# CITY OF ALBUQUERQUE

PLANNING DEPARTMENT – Development Review Services

**RE: Albuquerque Biopark Zoo Penguin Exhibit (File: K13D034G)**  
**Grading & Drainage Plan, Engineer's Stamp Date 9-15-2016**  
**Supplemental Information, Engineer's Stamp Date 10-5-2016**

STORM DRAIN SYSTEM: SUMP PUMPS

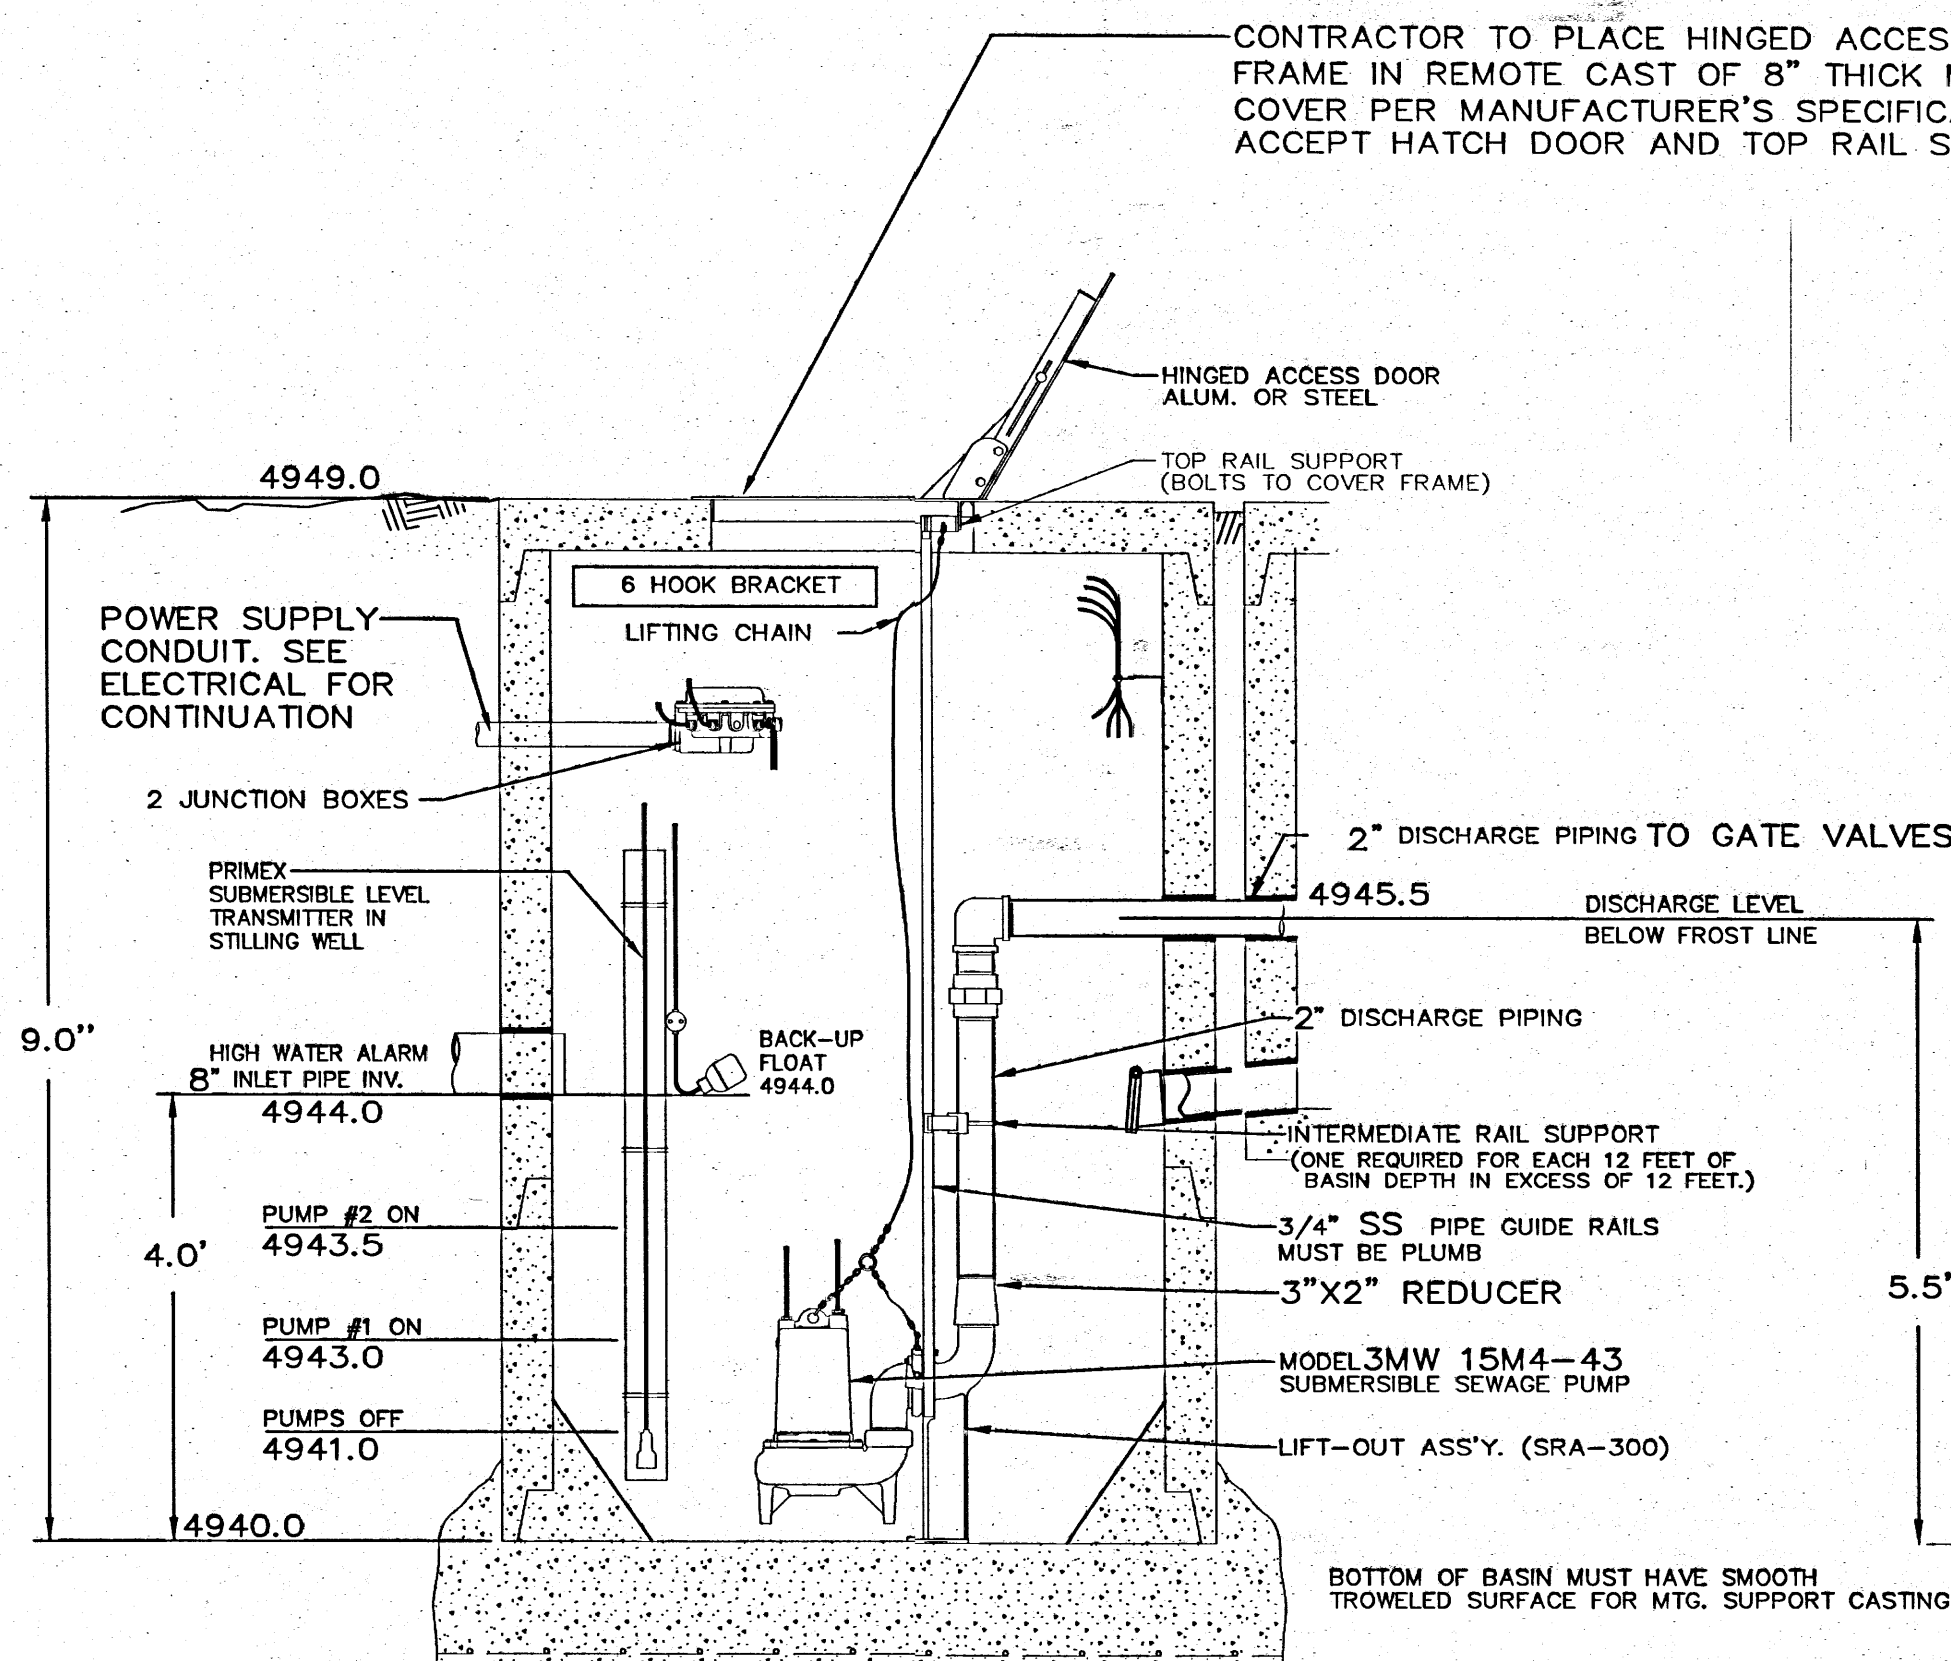
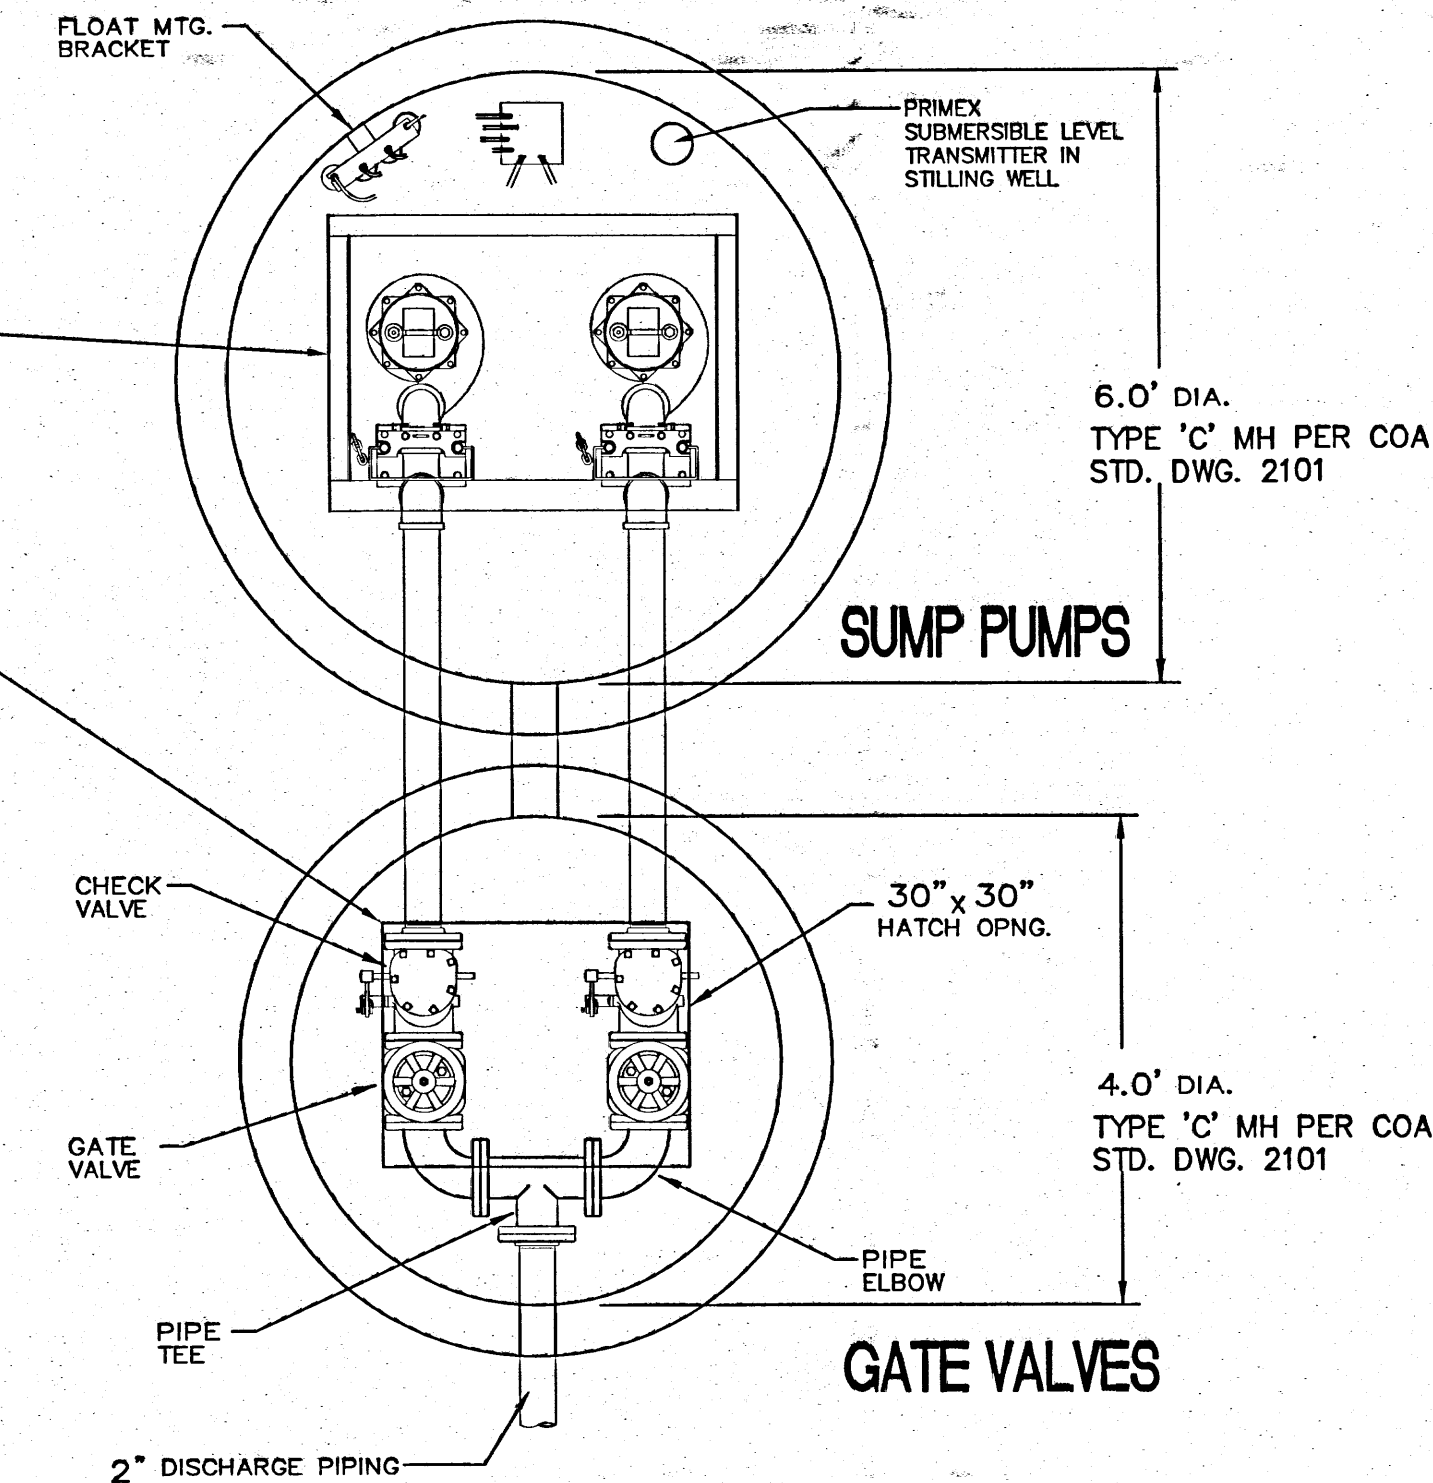
1. The WUA must accept drainage from the trench drains into the sanitary sewer. Verify with Jane Rael (505-289-3439).
